**CITY OF ALBUQUERQUE  
PLANNING DEPARTMENT  
September 16, 2015  
DRB Comments**

**PROJECT # 1001398          APPLICATION # 15DRB-70321**

**RE: Lot 7, Coleman Addition**

PLAT

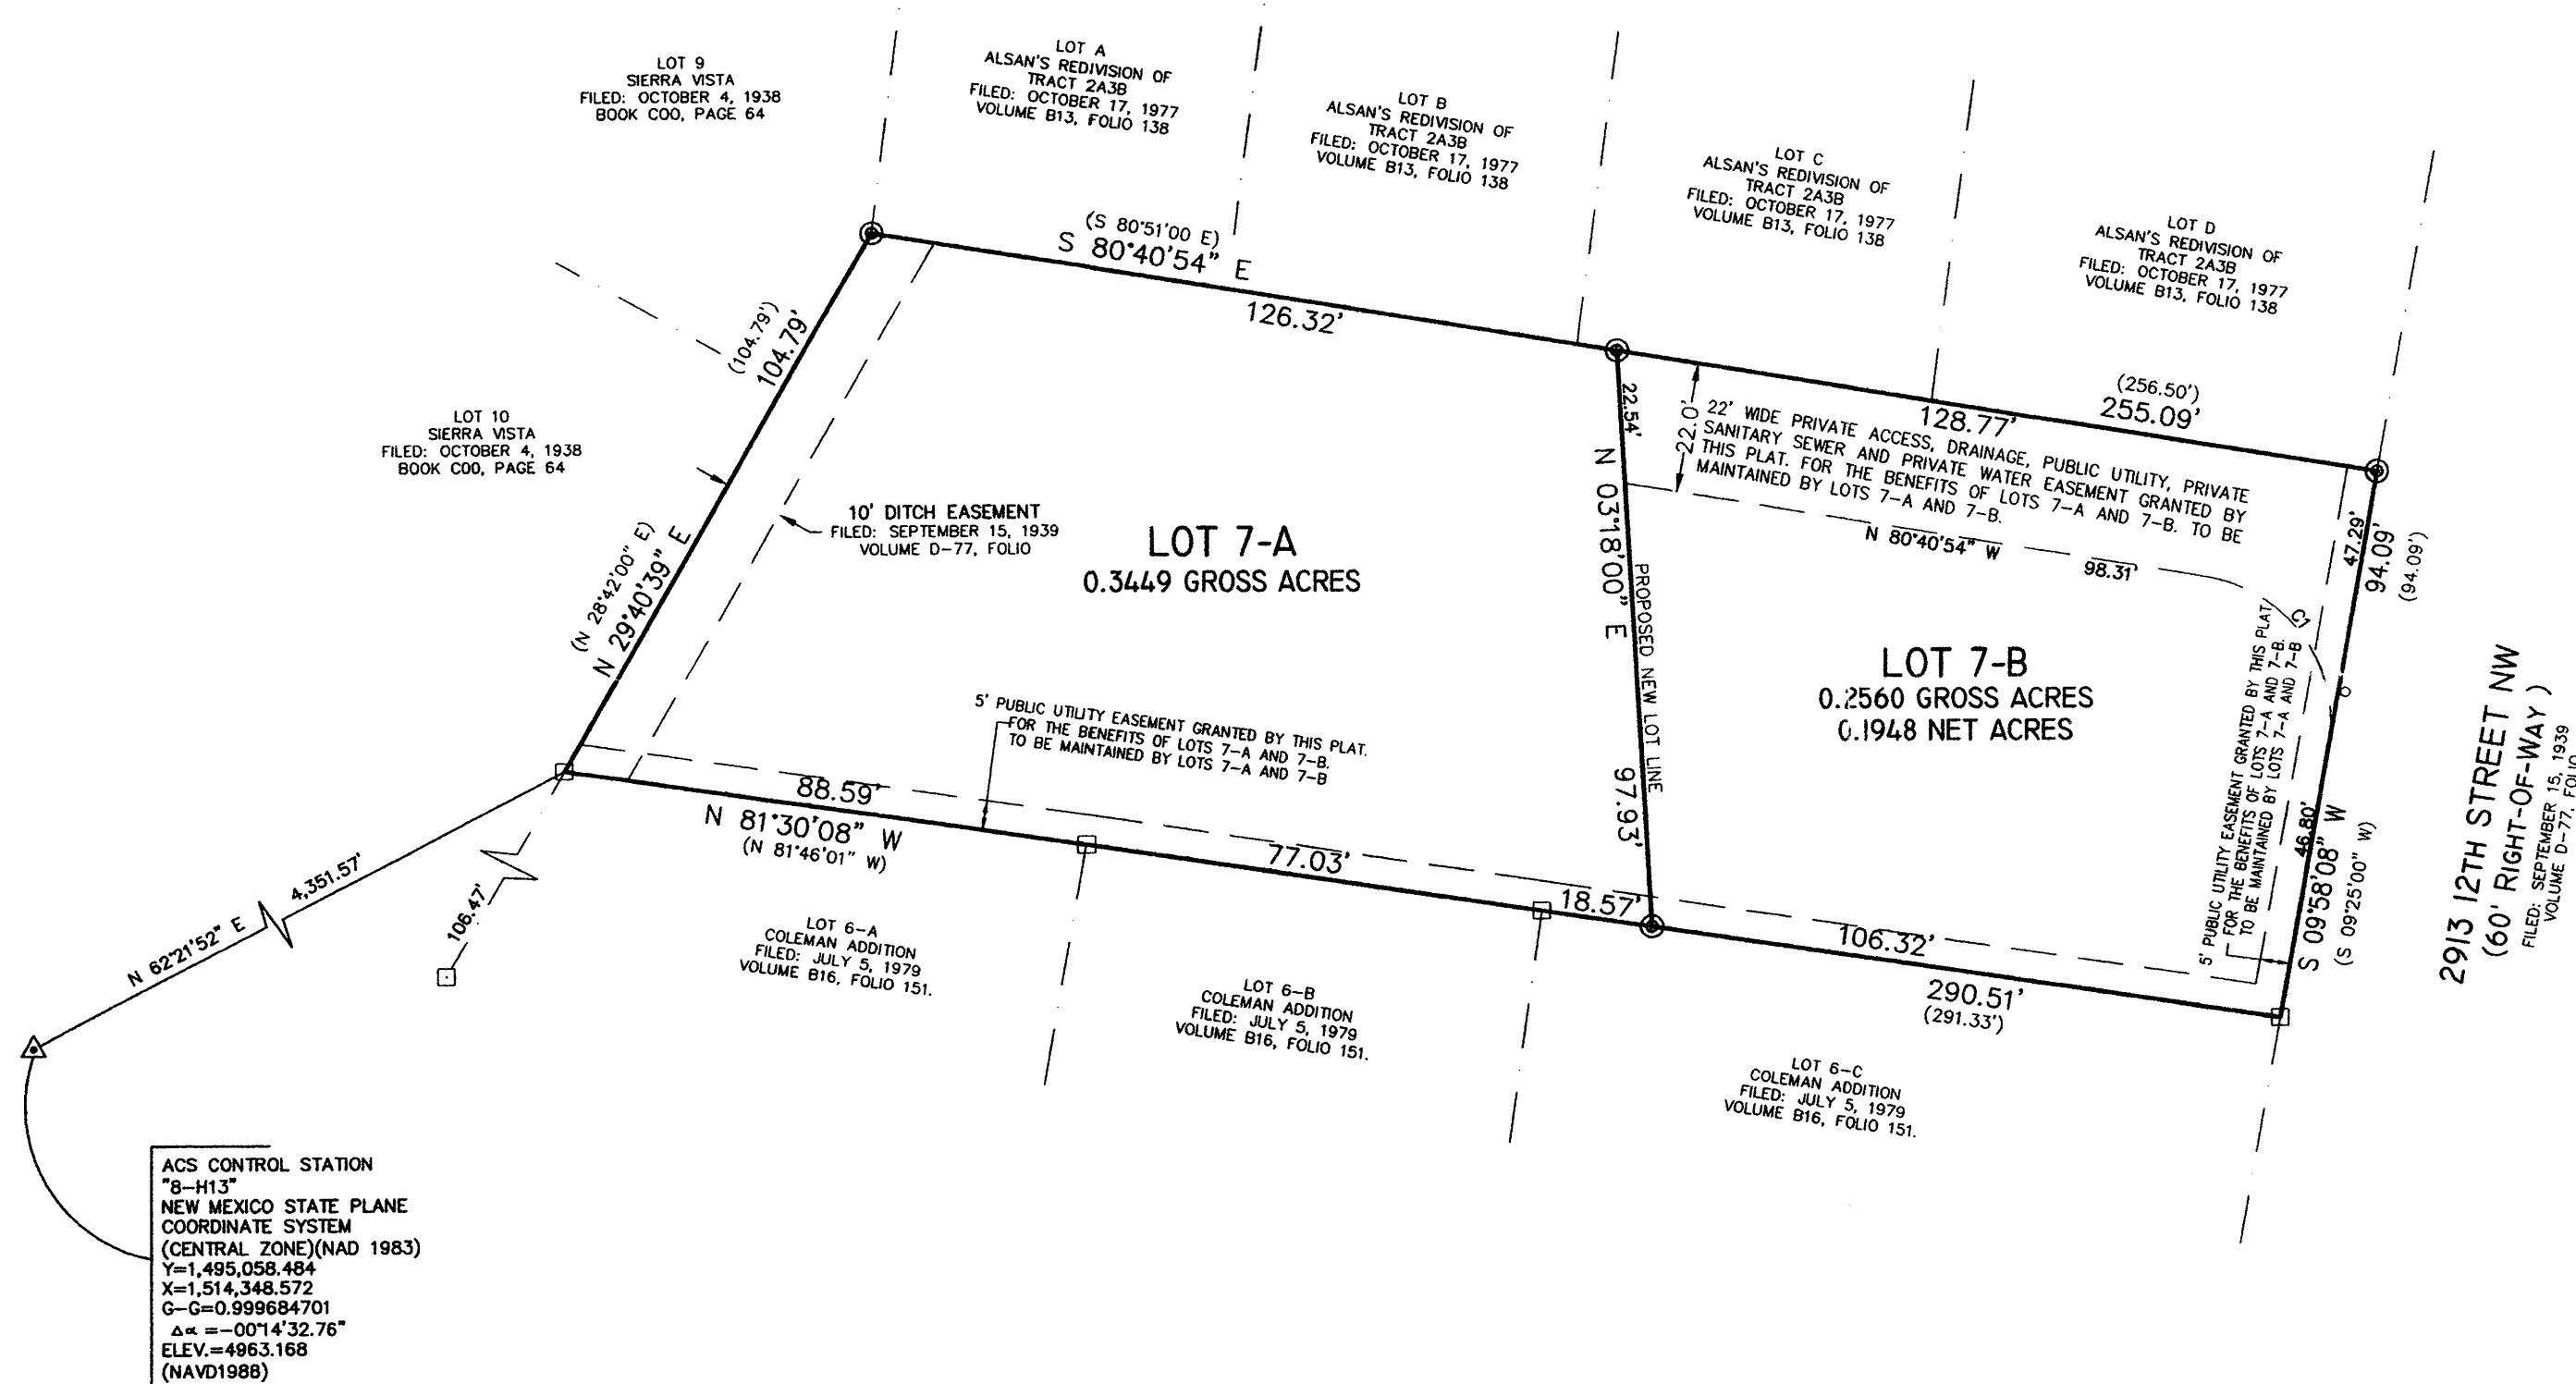
A site sketch is needed to demonstrate compliance with R-1 rear yard setback of 15 feet for the front lot.
